Kent County Council's response to the Department for Transport's request for comments and further information (letter dated 17 January 2020)

5. The Secretary of State invites the views of Kent County Council on the proposed mitigation for off-site junction improvements schemes included in the Unilateral Undertaking in favour of the County Council.

ANNEX 3
PRoW PLAN

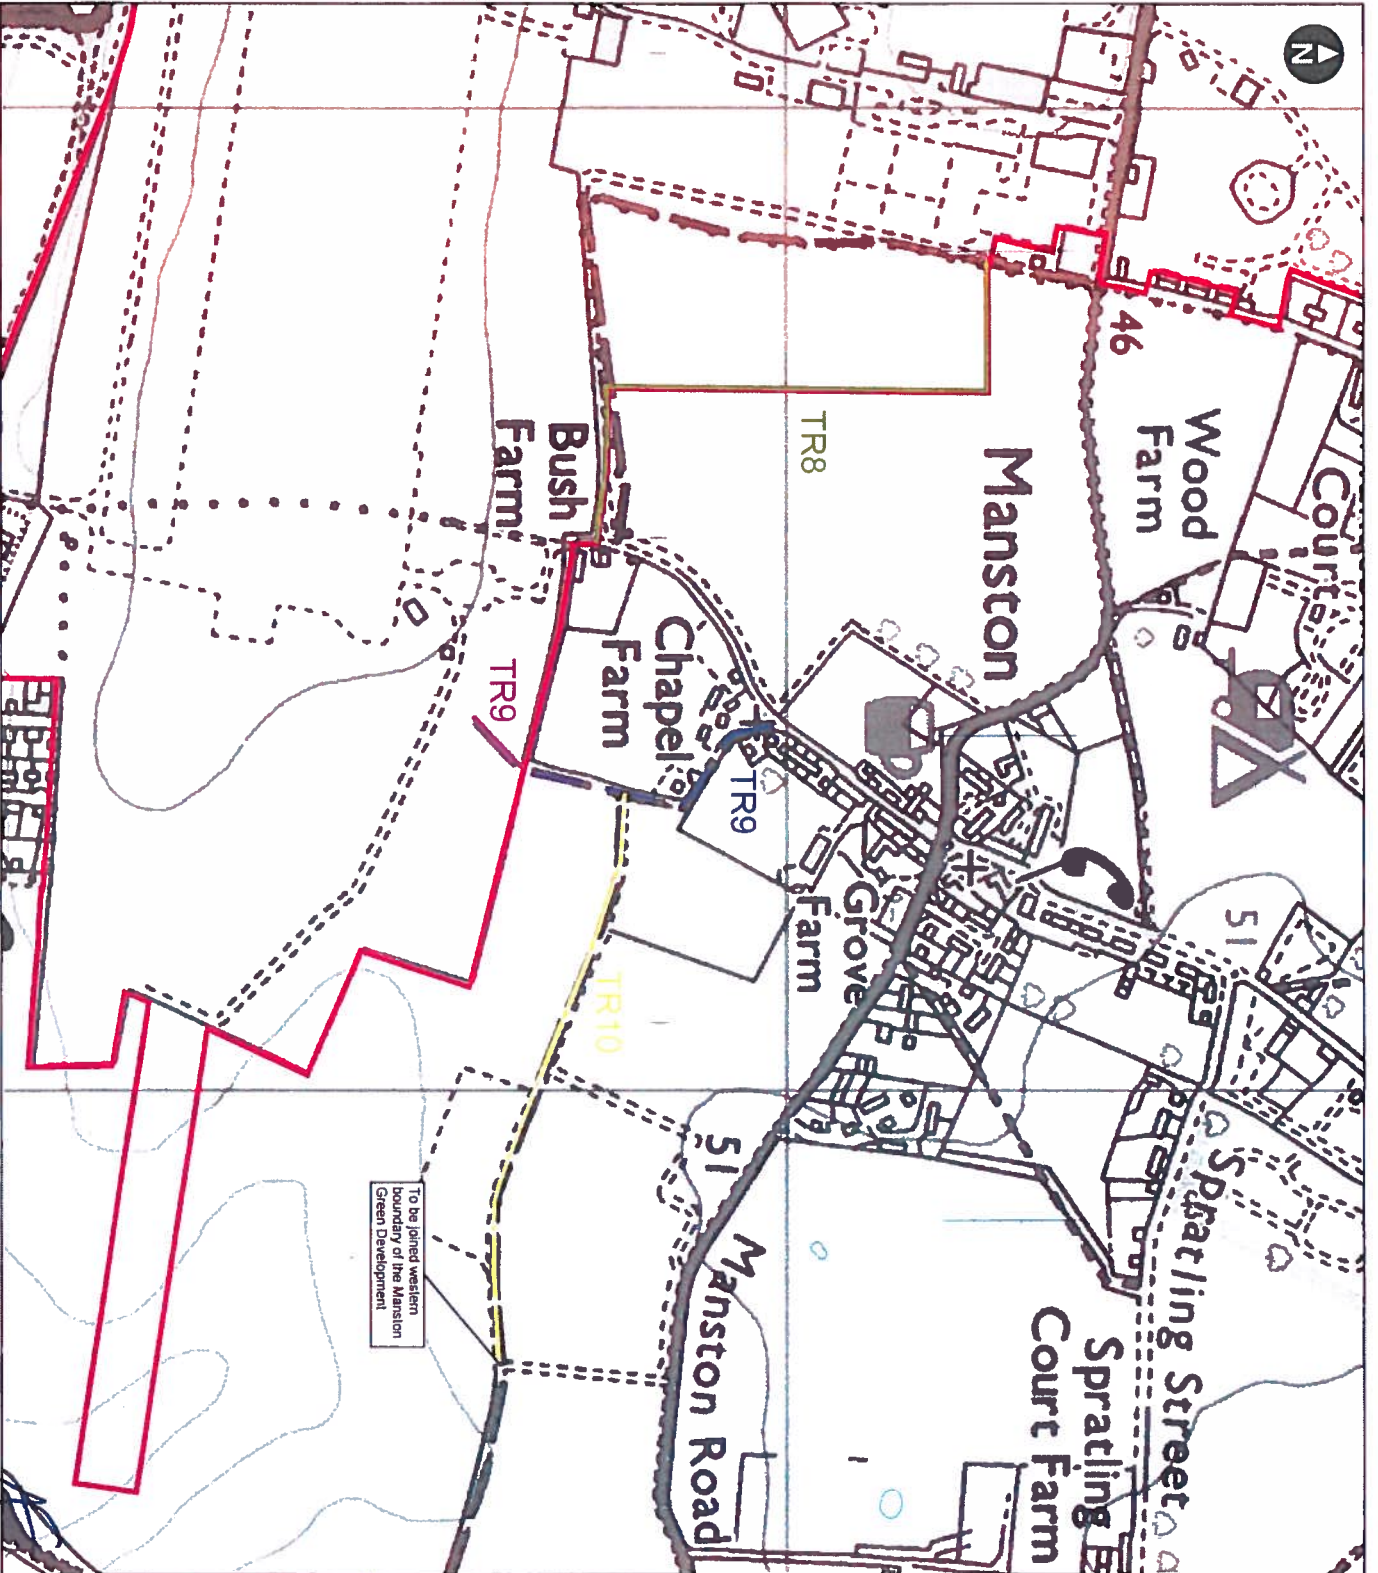
8. The Secretary of State invites the Applicant and Kent County Council to provide clarification on the reason for the contradiction in the approach initially adopted by the Applicant in consideration of the costs and methodology regarding the improvements to the Public Right of Way to Manston village to allow pedestrian access.

The contradiction between the original draft Section 106 agreement and the final UU is due to the fact that the initial proposal was drawn up by the Applicant before full consultation with KCC Public Right of Way (PRoW) Officers. The draft Section 106 agreement did not address the connectivity of the site and improvements required to the wider PROW network. The final UU reflects KCC's PROW response to the Fourth Written Questions, referenced TR 4.54 and is therefore in accordance with KCC's PROW requirements.

ANNEX 4
OFF-SITE JUNCTIONS PLAN

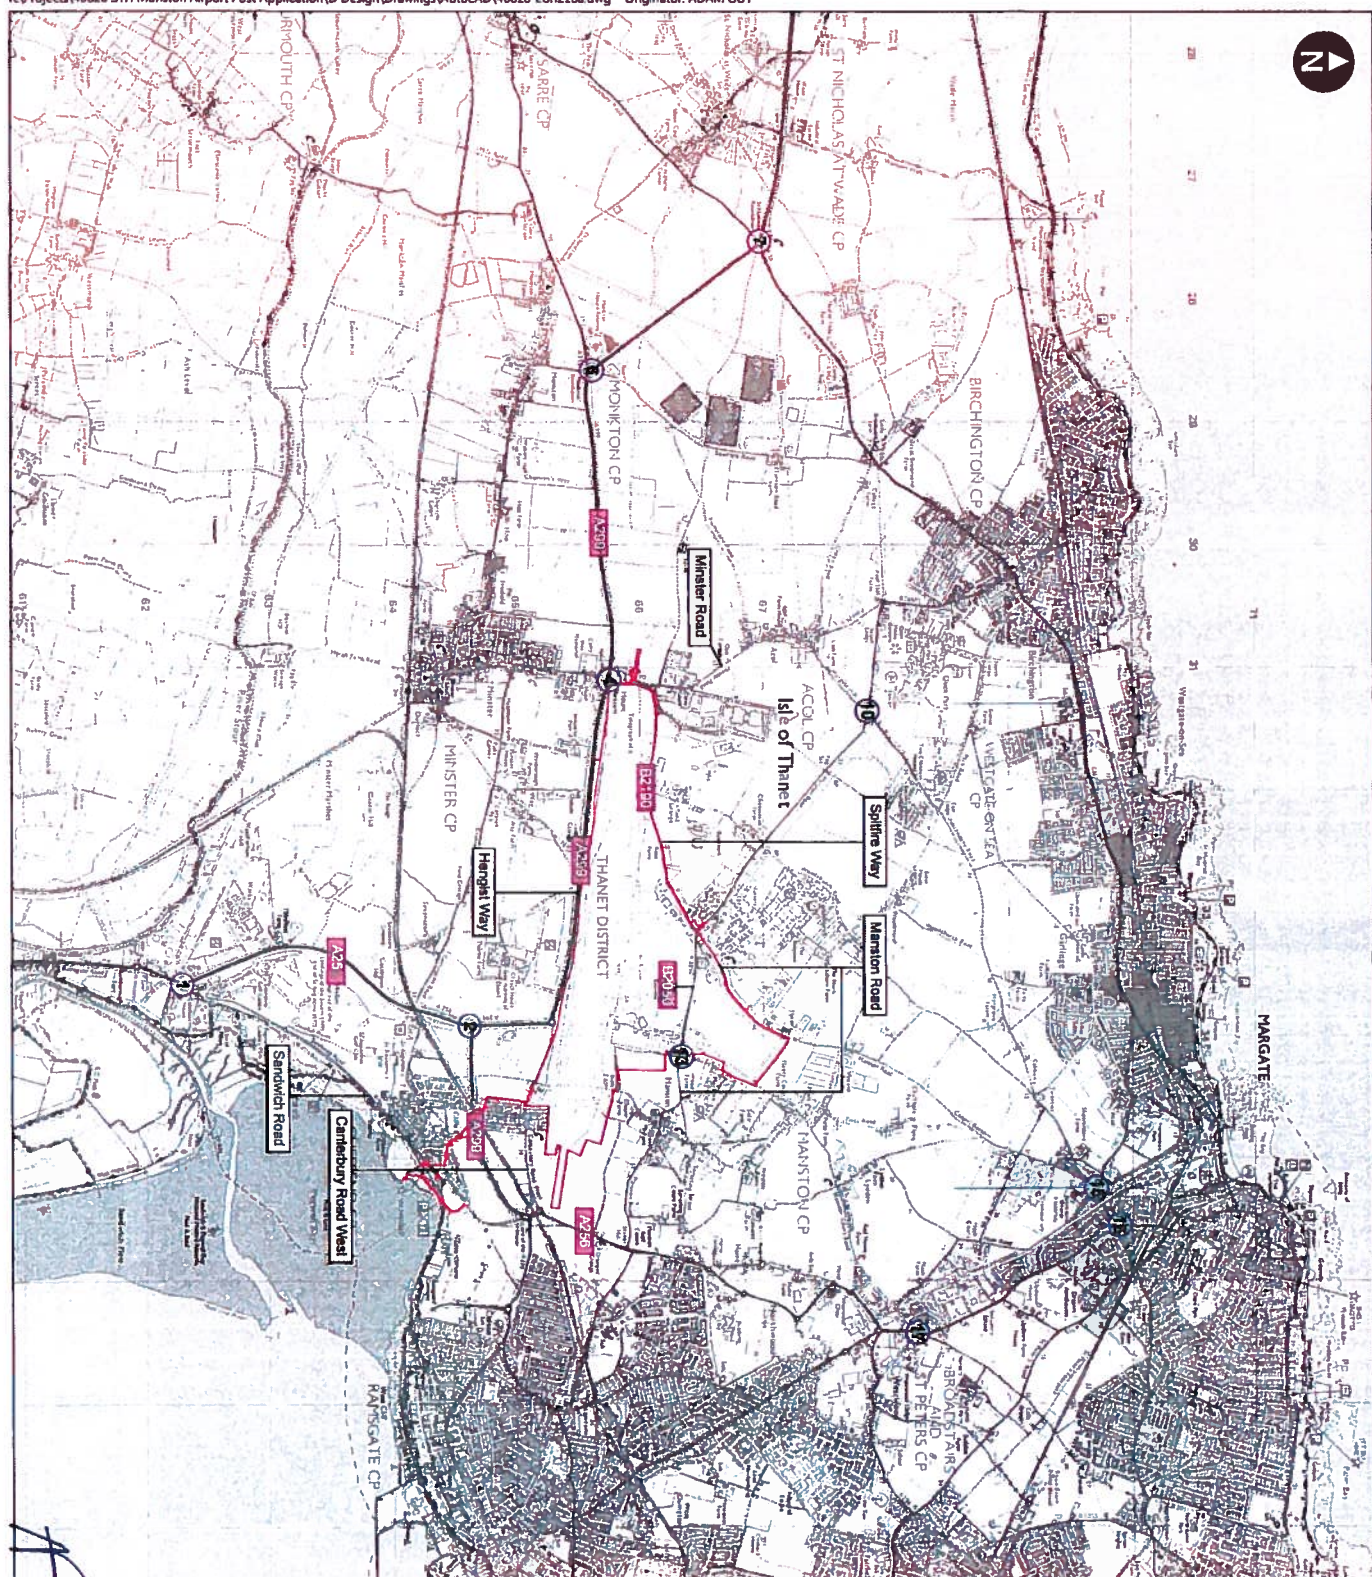
Junction 1 (A256 / Sandwich Road): The position of KCC is set out in the County Council's Local Impact Report (LIR). KCC's assessment is that it is unlikely that the proposed mitigation scheme will deliver any practical benefits to junction capacity/operation of the junction and so it would not mitigate the impact of the proposed development. As such, KCC does not consider the proposed scheme to meet the regulation 122 CIL Regulations 2010 tests. Therefore, KCC does not consider the proposed mitigation to be an acceptable basis for a financial contribution within the UU.

Junction 2 (A299 / A256 / Cottington Link Road): KCC's position is outlined in the response to the Fourth Written Questions (TR.4.23) The proposed scheme is not considered to appropriately mitigate the impact from the development as it would lead to an increased likelihood of road traffic collisions and vehicular conflict in this location.

Junction 4 (A299 / B2190): KCC's position is outlined in its response to Fourth Written Questions (TR.4.24). The proposed scheme is not considered to appropriately mitigate the impact from the development as it would lead to an increased likelihood of road traffic collisions and vehicle conflict.

Junction 6 (A299 / Seamark Road / A253 / Willetts Hill): KCC's position is outlined in the response to the Fourth Written Questions (TR.4.25). The proposed scheme is not considered to appropriately mitigate the impact from the development, as it would lead to increased likelihood of road traffic collisions and vehicle conflict in this location.

Junction 7 (A299 / A28): The position of KCC is set out in the responses to the Third Written Questions (TR.3.27) and the Fourth Written Questions (TR.4.26). The proposed mitigation is not considered to appropriately mitigate the impact from the development. In particular, KCC considers that the proposed layout changes are likely to increase the likelihood of side swipe road traffic collisions, to the detriment of highway safety.

Junction 10 (Shottendane Rd / Manston Road / Margate Hill): The position of KCC is outlined its response to Fourth Written Questions (TR.4.28) This scheme is acceptable in principle.

Junction 13 (Manston Court Road / B2050): The position of KCC is set out in response to the Fourth Written Questions (TR.4.28) and the LIR. This mitigation scheme would not be deliverable within the extent of existing highway boundary. As neither KCC or the applicant has legal rights over the land required to implement the proposed mitigation (and the land is not included within areas of land identified for compulsory purchase in relation to the DCO), this scheme is not deliverable without further investment.

Junction 15 (Manston Road / Hartsdown Road / Tivoli Road / College Road / Nash Road): The views of KCC are outlined in the response to the Fifth Written Questions (TR 5.4), the Second Written Questions (TR.2.42) and the KCC LIR. The concerns previously set out in the aforementioned documents remain KCC's position. The applicant has failed to respond and address those concerns in a satisfactory manner.

Junction 16 (Ramsgate Road / College Road / A254 / Beatrice Road): The views of KCC are outlined in the response to the Fourth Written Questions (TR.4.32) and the Second Written Questions (TR.2.43). The proposed mitigation is not considered to effectively address the impact of the development. It will disadvantage pedestrians (of particular concern is that this junction is located close to a primary school and several local shops). It will also lead to an increased risk of road traffic collisions as the proposed reconfiguration will lead to blocking back of the junction by queuing traffic and restricted intervisibility between the signal stop lines in this location.

Junction 17 (Ramsgate Road / Poorhole Lane / Margate Road / Star Lane): The position of KCC is outlined in the response to the Fourth Written Questions (TR.4.33) and the KCC LIR. The proposed scheme of mitigation is not considered to deliver any practical benefits to the capacity of this junction.
